Subject: Y/3/22/OUT

Land West of Bilsham Road Yapton

Hybrid Application comprising of Full application for Phase 1 for 30 No residential dwellings, new access from Bilsham Road, public open space, landscaping, sustainable urban drainage and associated works; and Outline planning application for further phases of up to 110 No dwellings and associated infrastructure (with all matters reserved).

Martyn White
Principal Conservation Officer,
Planning Services

Illustrative Landscape Masterplan 964-MP-02B
(Indigo Landscape Architects)

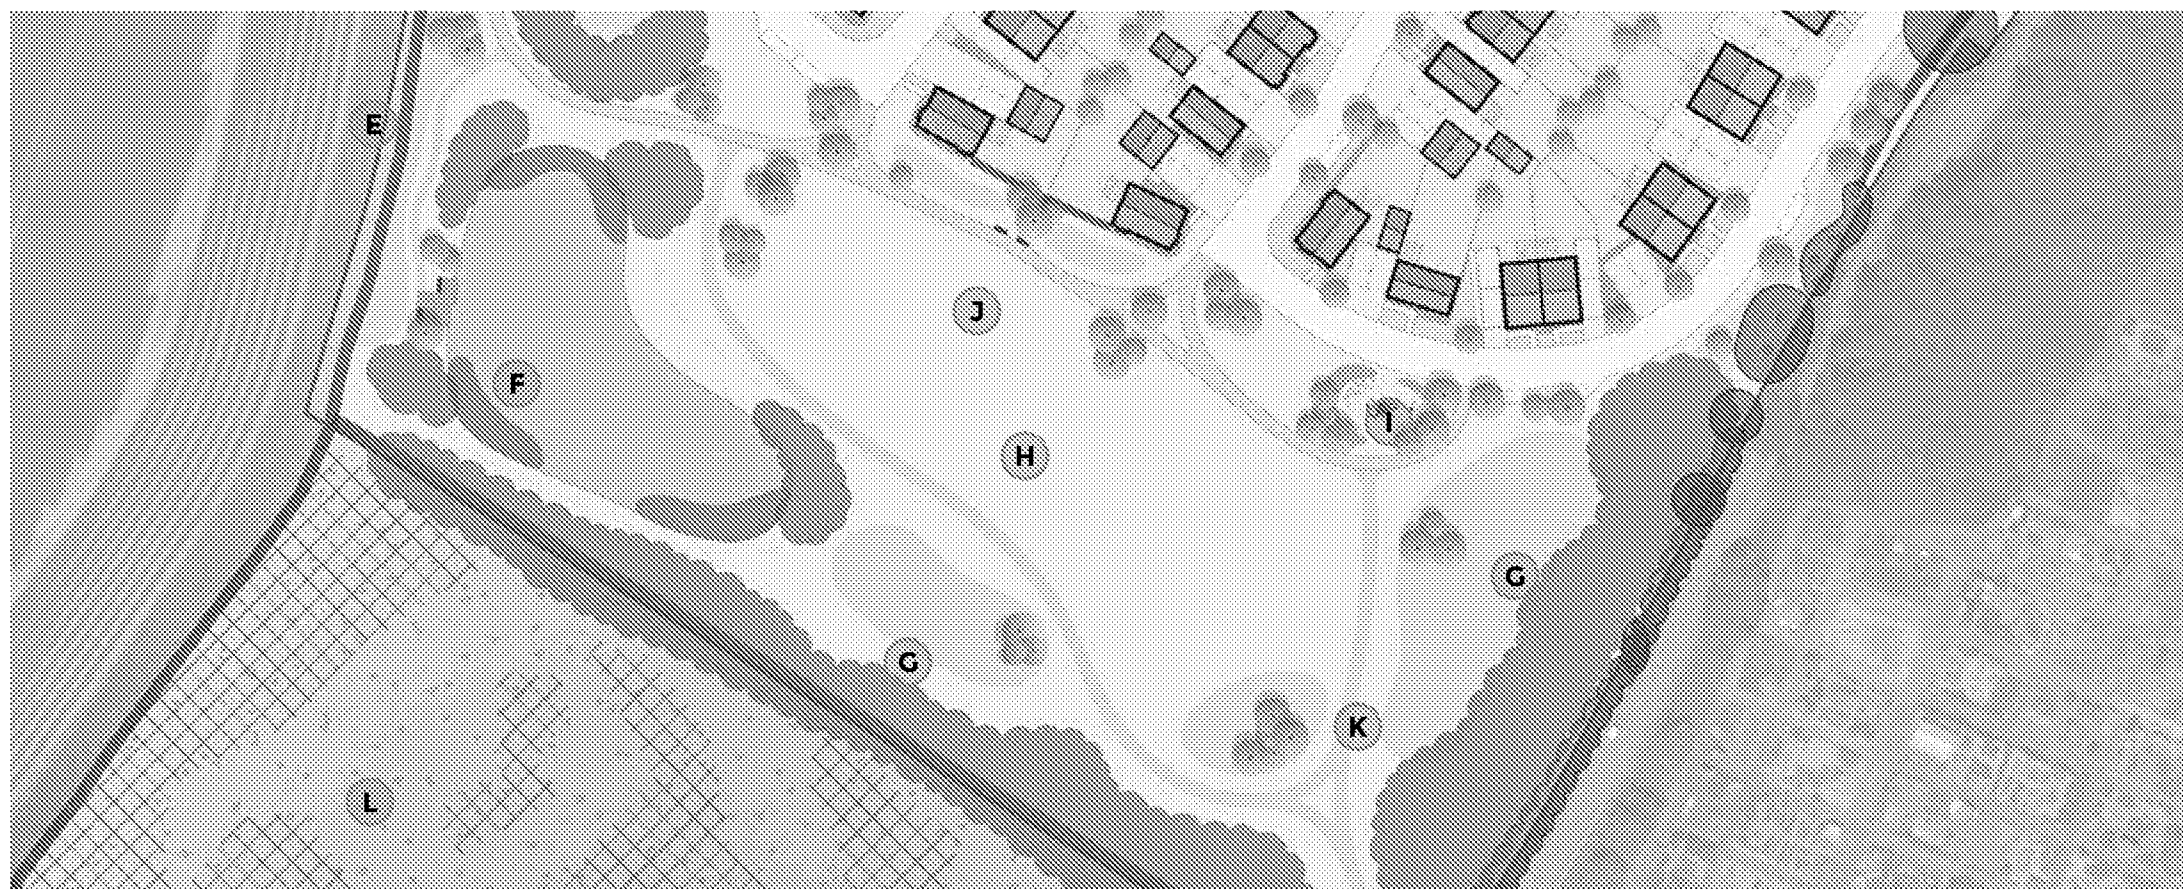
I note that an Illustrative Landscape Masterplan has been provided for the entire of the site which shows that development would be concentrated to the northern parts which would leave the southern part of the (that which is closest to the listed buildings) as an area of green open space, with new woodland and tree planting. Paragraph 4.2 of the Heritage statement also states that whilst outside of the red line boundary, the area to the immediate south of the site could be retained as a separate biodiversity improvement area, which would further maintain a landscape buffer between the listed buildings and new built form within the developed site. This area appears to be shown identified with a blue line boundary. If this area is not located within the red line boundary, could this proposal be enforced if not provided?

The Illustrative Landscape Masterplan identifies that the proposed housing would accommodate approximately 75% of the red site area (my estimate) and would be located to the north, which would leave a large area of land to the southern part as green open space. This open space would include an attenuation pond and new tree and woodland planting. Such planting should be located on the southern boundary of the redline site in order to soften the development into the surrounding countryside. The proposed planting would mature with time, and along with the location of the housing would mean that this would limit any intervisibility with the listed buildings in Bilsham/hamlet of Bilsham.

Outside of the red line boundary, but to the immediate south of the site, further land is identified as biodiversity improvement area. The heritage statement notes that it would remain free of any new built form and maintain the landscape buffer between the new houses and the listed buildings to the south along Bilsham Lane. I also note that the existing southern boundary of this area is identified with existing vegetation, which could be sensitively enhanced as part of this element of the scheme. However, if the land is not within the red line, would it be possible to require that the land was used as such?
